Rezoning Transportation Analysis
Petition Number: Insert Zoning Petition #2021-215
General Location Identifier: 03144101

From: Brandon Brezeale, PE
Brandon.Brezeale@charlottenc.gov
704-432-5561

Date	Description
01-24-2022	First Review (KP)

SCHEMATIC  
SITE PLAN

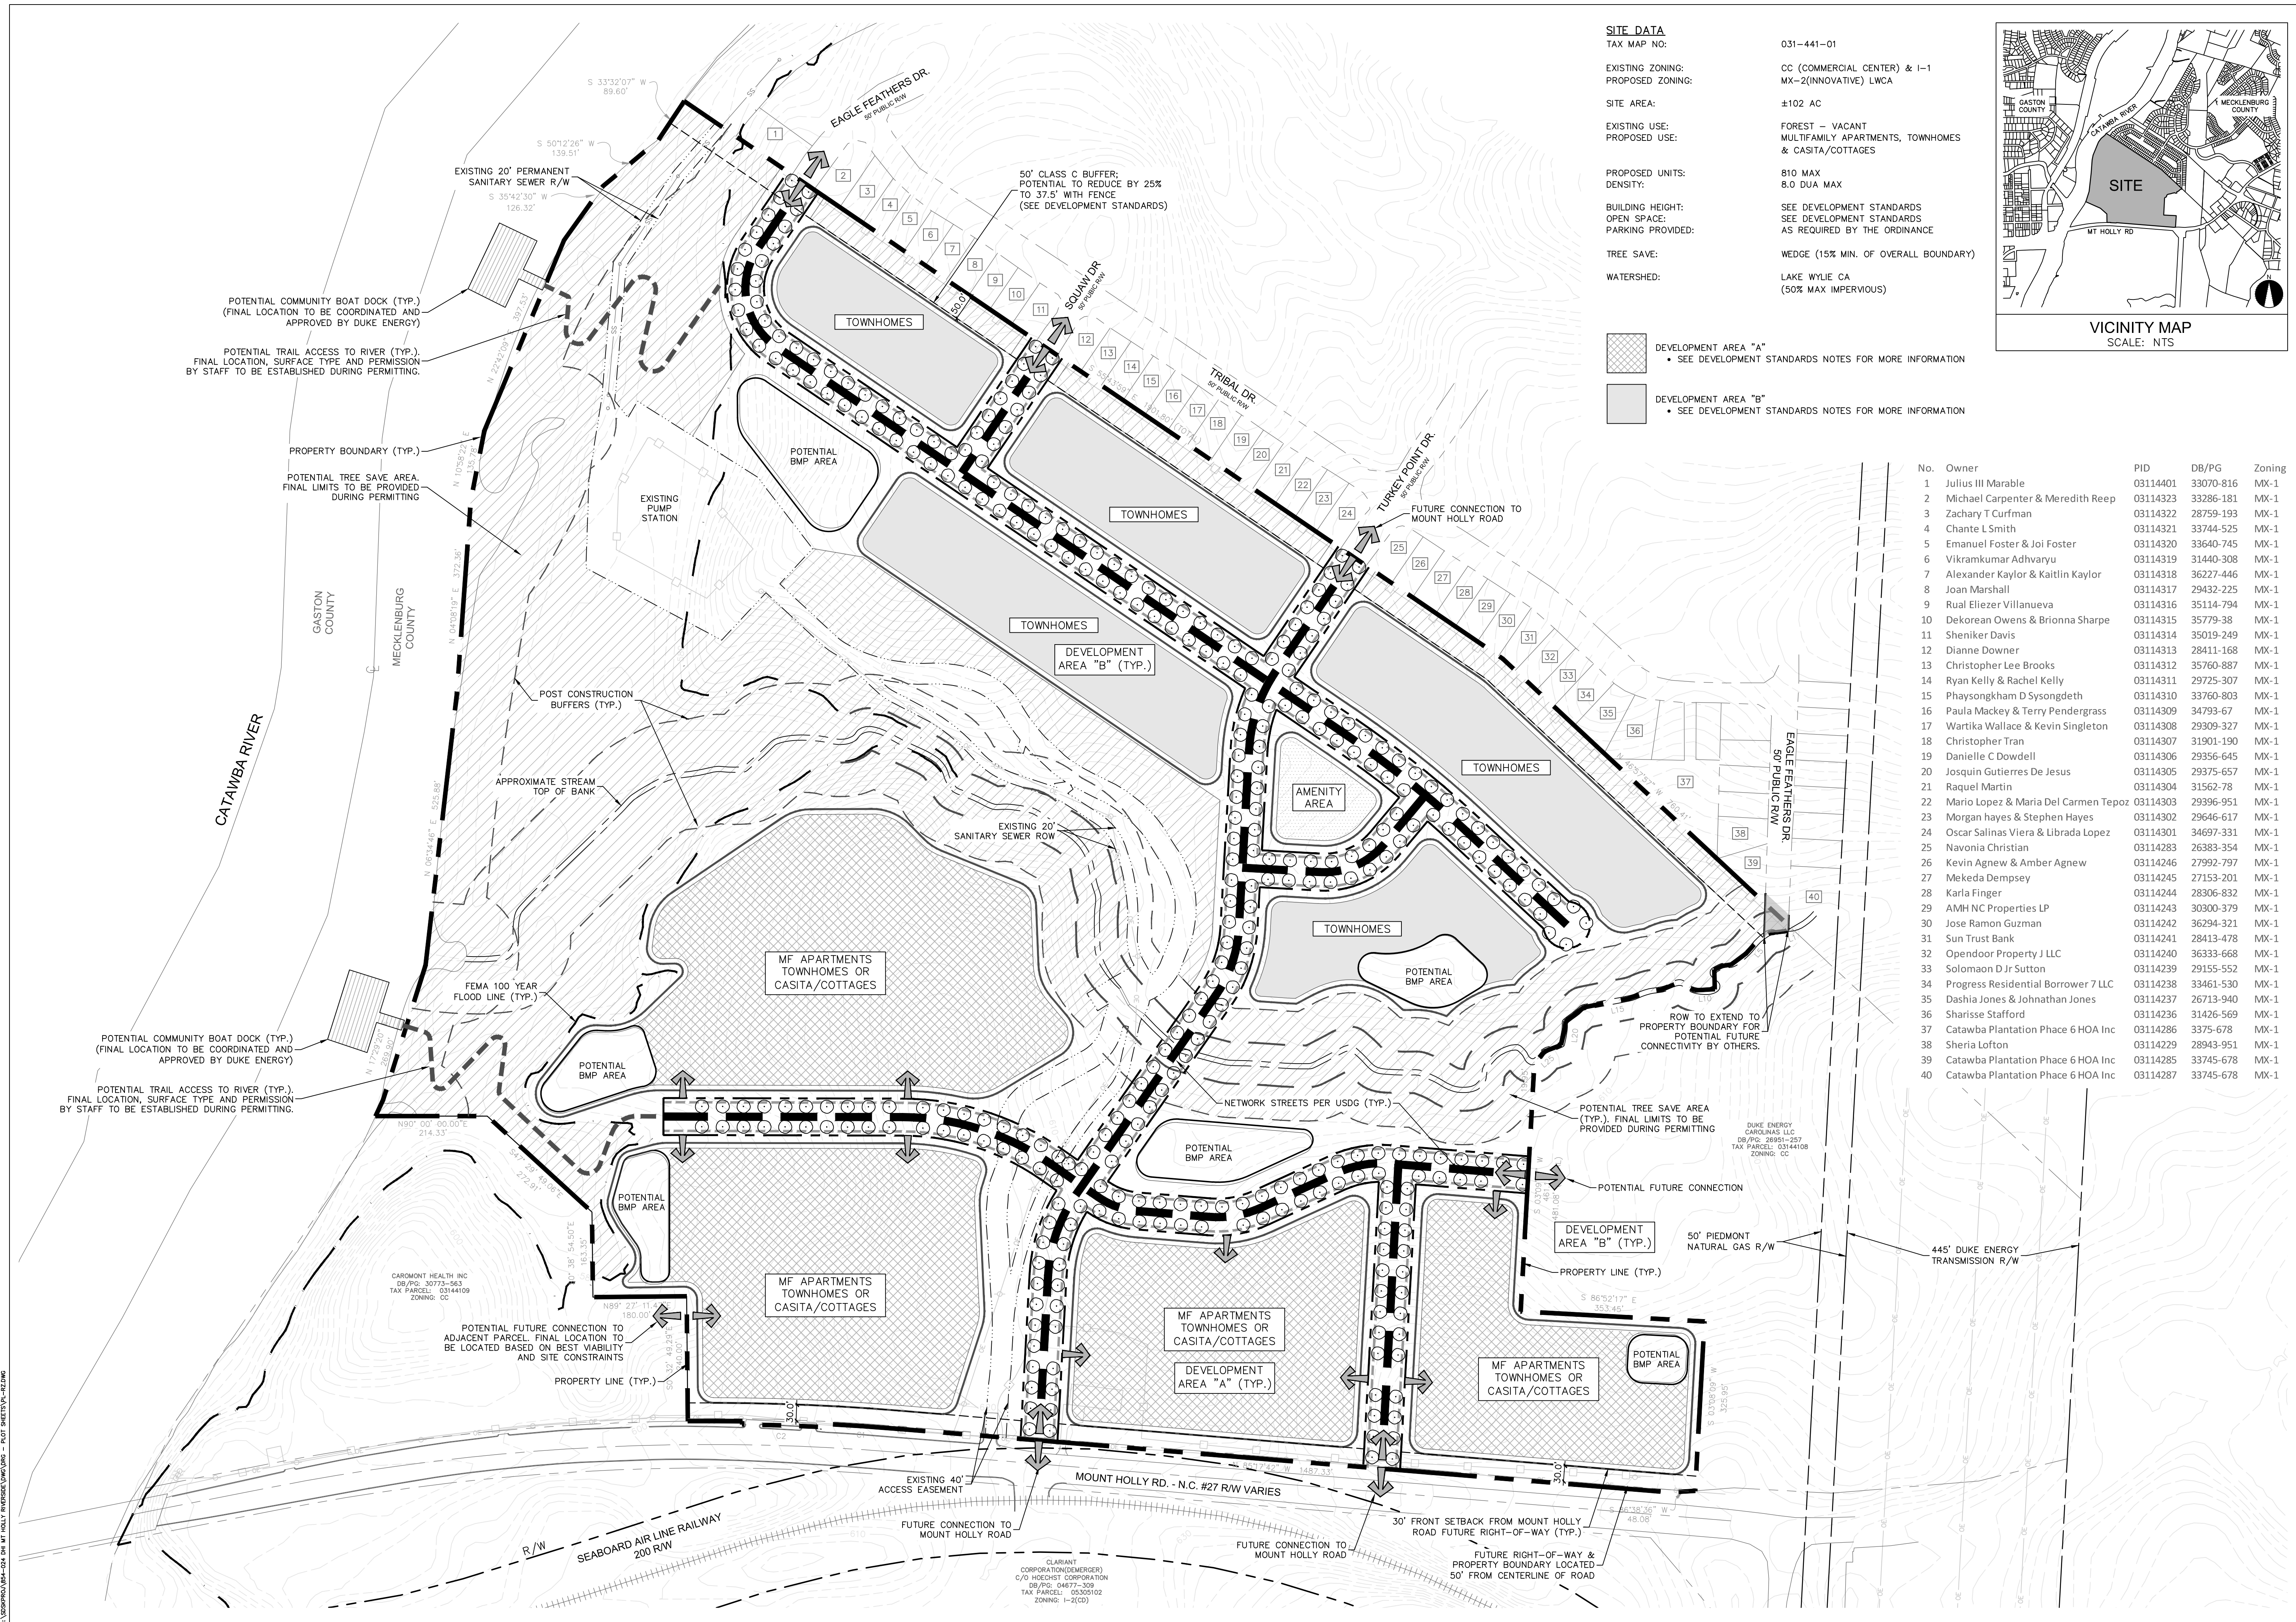
1. Curb line:

- a. **Mount Holly Road:** Curb line location shall be incorporated on the site plan pending approval of the TIS.

The site plan shall label and dimension the curb and gutter from the centerline.

- 3. Revise site plan and conditional note(s) to commit to dedicate 52-feet of right-of-way from the existing Mount Holly Road centerline. The site plan shall label and dimension the right-of-way from the existing road centerline.

- 5. Revise the site plan and conditional notes to commit to construct an 8-foot planting strip and 12-foot shared-use path along the site's frontage of Mount Holly Road. The planting strip and shared-use path will be located relative to the back-of-curb location of Mount Holly Road.

- 6. Revise the site plan and conditional notes by labeling each internal public street. Additionally, include the relative CLDSM USDG Cross Section(s) that each internal public street will be designed and constructed in accordance with.

7. Revise the site plan and conditional notes by committing to design and construct the public street, proposed to extend from Mount Holly Road and connect to existing Turkey Point Drive, in accordance with CLDSM USDG U-07 Local Collector Street Cross Section.

8. Revise the site plan by extending the western street stub to the southwest rezoning property line. Additionally, remove the multifamily east-west connection to the adjacent parcel.
